Historic England

Our ref: P01142681

**BICESTER HERITAGE, BUCKINGHAM ROAD, BICESTER, OXFORDSHIRE, OX26
5HA
Application No. 19/02708/OUT**

F.A.S.T. Indicative Layout Plan

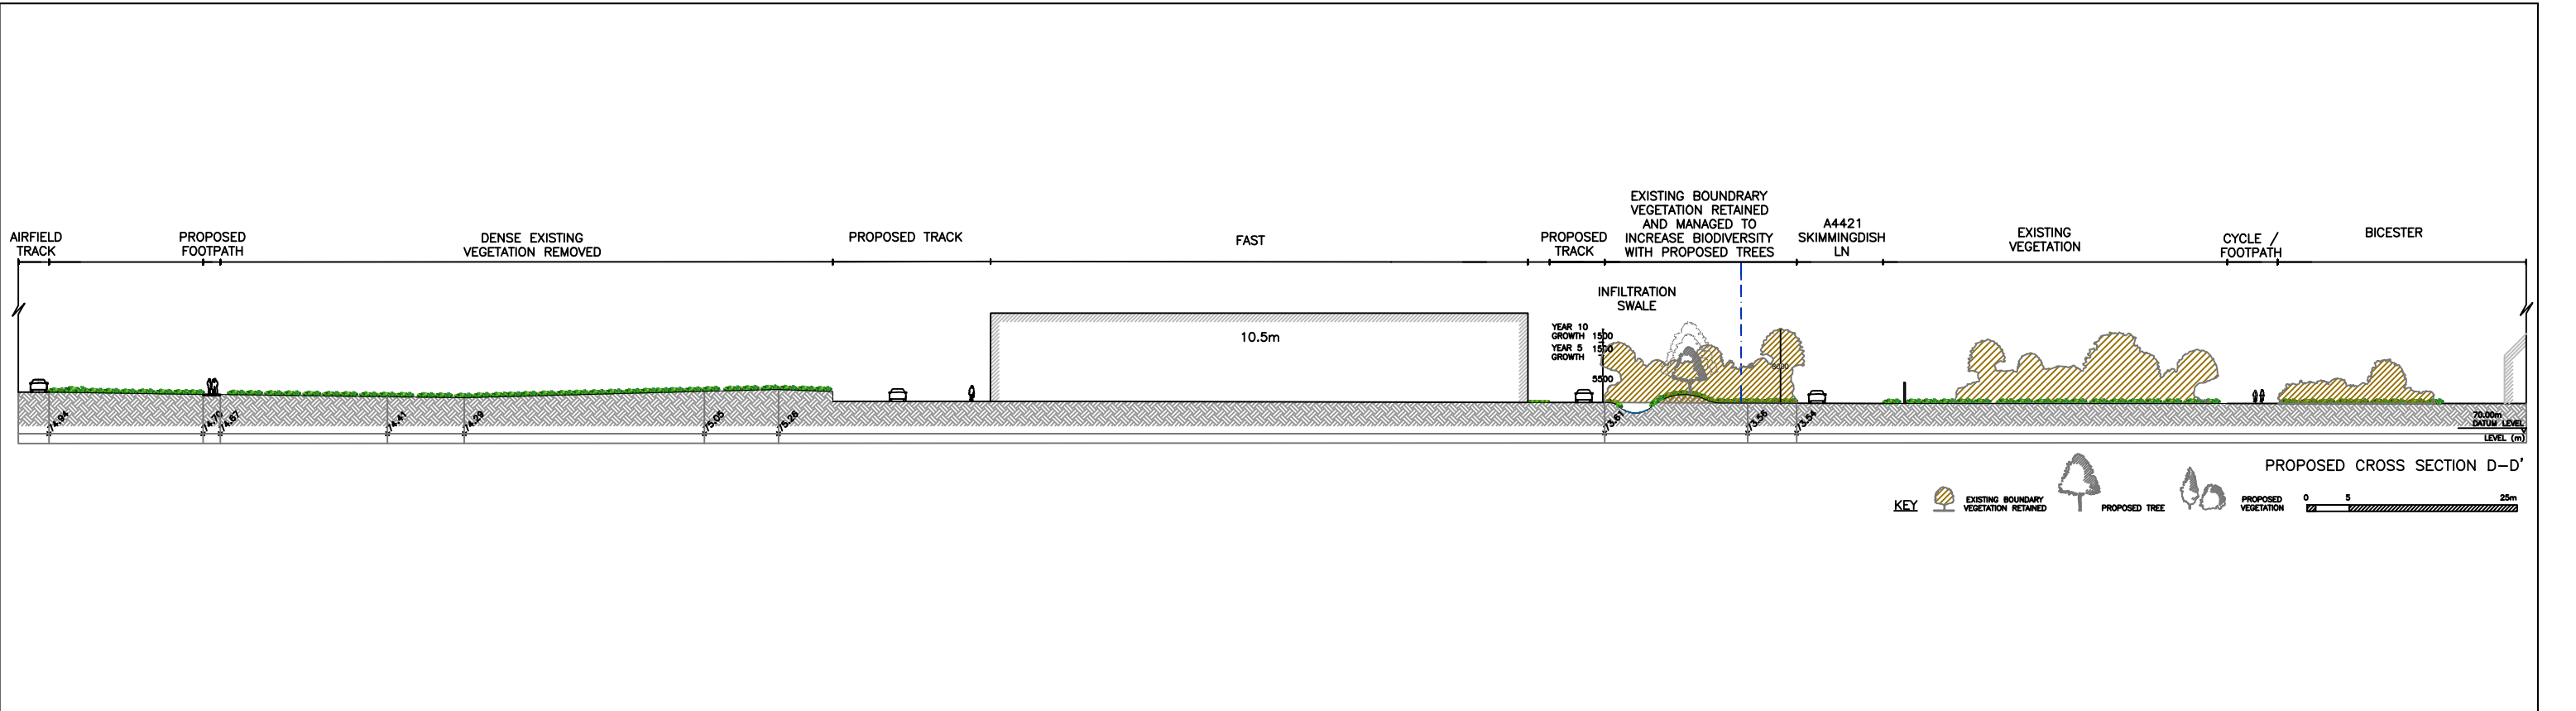
The proposed development will impact upon the appreciation of the function of the complex, insofar as it will make it harder to understand the operation of the south-west seagull trench because new buildings will effectively block much of the field of fire. It is the case that the setting in this direction has already been compromised to a degree by new buildings, but these are located some distance away across Skimmingdish Lane. There will therefore be harm to the significance of the historic asset.

This application is outline only, and if the local authority is minded to permit the proposal subsequent design will be critical. The location and spacing of the new buildings might be arranged in such a way as to allow an understanding of the original south-west aspect, and a clear architectural statement would need to be made to avoid any perception that the new buildings are part of the original complex. The landscaping would need to be carefully considered, in particular with significant tree- and shrub- planting avoided.

If planning permission is granted for this proposal, a condition should be attached requiring the submission of a management plan for the scheduled monument and the

surrounding area, setting out proposals for any necessary repairs and subsequent long-term management.
